Rezoning Transportation Analysis

Petition Number: 2020-121

Date	Description
09-14-20	First Review

RZ-1.0

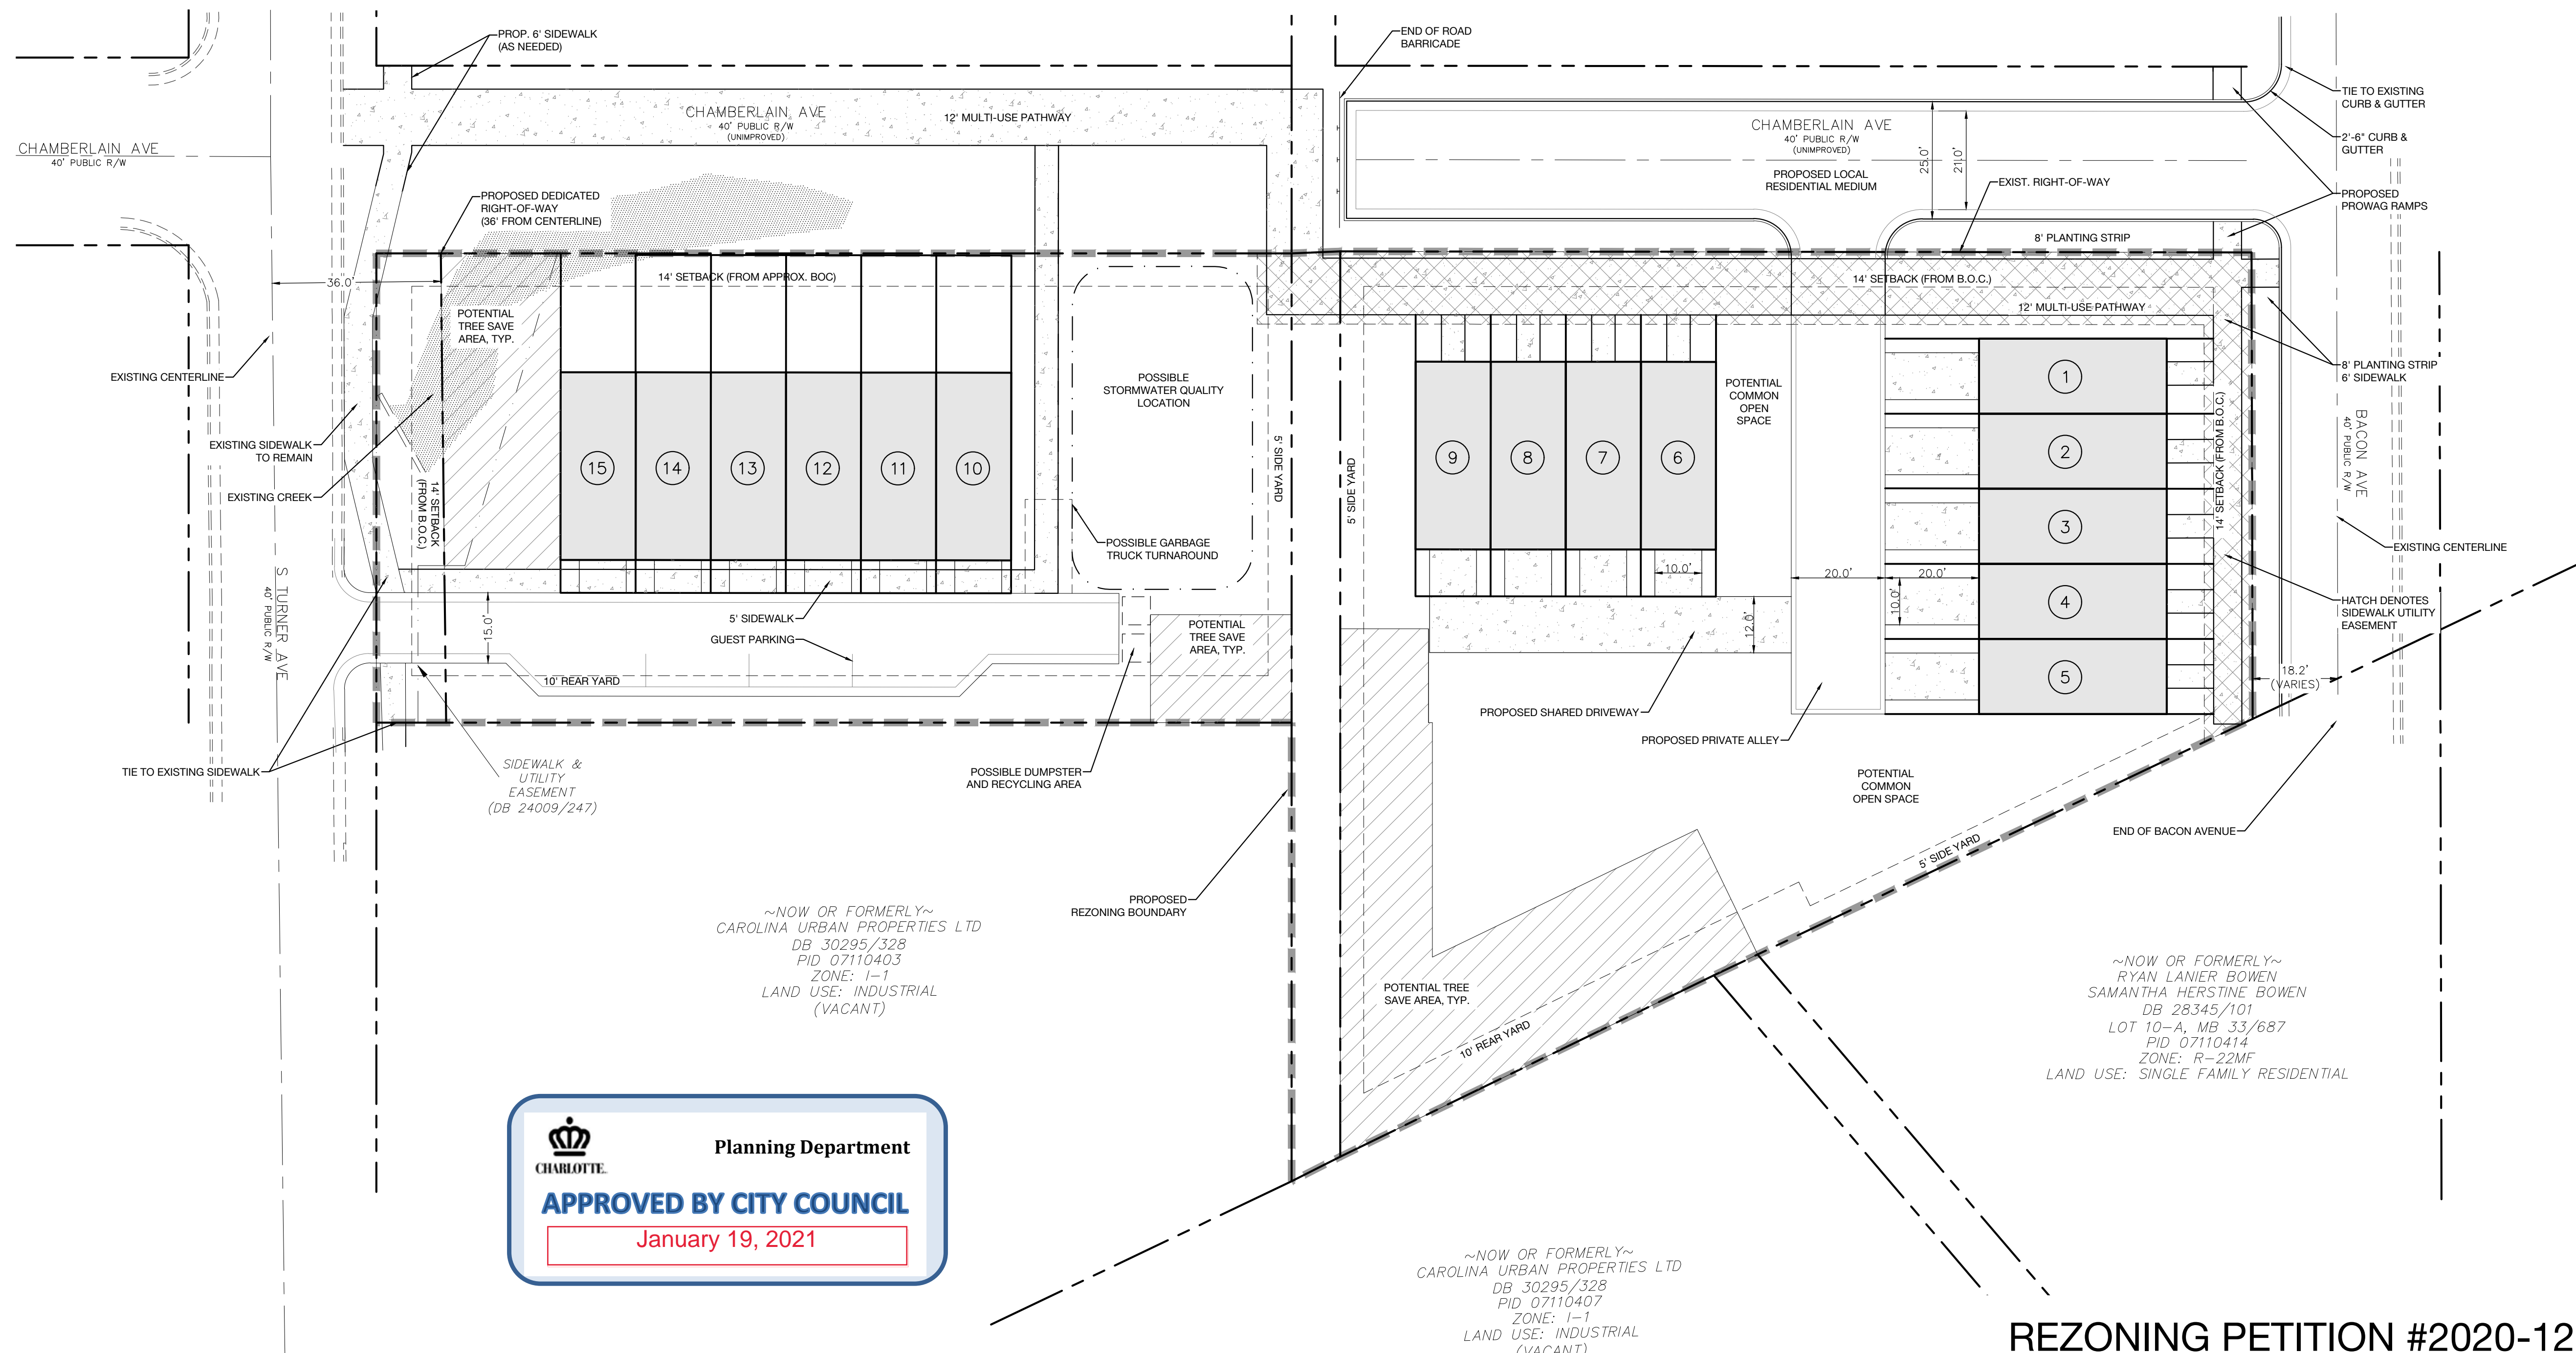
The site is located on Turner Avenue, a collector road. CDOT requests a 16-foot Multi-Use Path, as opposed to the typical 12-foot, to ensure connectivity and gain Powell Bill funding. The site plan should note that all transportation improvements and dedicated right-of-way be completed prior to the first building's certificate of occupancy being released.

- Revise the site plan and conditional note(s) to commit to dedicate 36-feet of right-of-way from the Turner Avenue road centerline, labeled and dimensioned from the road centerline, in accordance with Charlotte Land Development Standards Manual (CLDSM) Urban Street Design Guidelines (USDG) standard detail number **U-07 – Local Collector Street Typical Section**.

- Revise the site plan and conditional note(s) to provide two PROWAG ramps per intersection corner, at the intersection of Chamberlain Avenue and Bacon Avenue, if roadway is constructed within the Chamberlain Avenue unmaintained right-of-way.

- Revise the site plan and conditional note(s) to tie-in the proposed multi-use path at the Turner Avenue and Chamberlain Avenue intersection.

7. Revise the site plan to add a note specifying dedication and fee simple conveyance of all rights of way to the City before the site's first building certificate of occupancy is issued. CDOT requests right of way set at 2' behind back of sidewalk where feasible.
8. Revise the site plan to add a note specifying all transportation improvements will be approved and constructed before the site's first building certificate of occupancy is issued. The petitioner may phase transportation improvements if said improvements and phasing are explicitly described in site plan notes.
9. To attain a street and pedestrian lighting recommendation, the petitioner should coordinate with Anthony Mendez, CDOT. Please visit the following link:
<https://charlottenc.gov/Transportation/Programs/Pages/StreetLighting.aspx>
10. ~~Resolved~~ Sample format for comment that is resolved
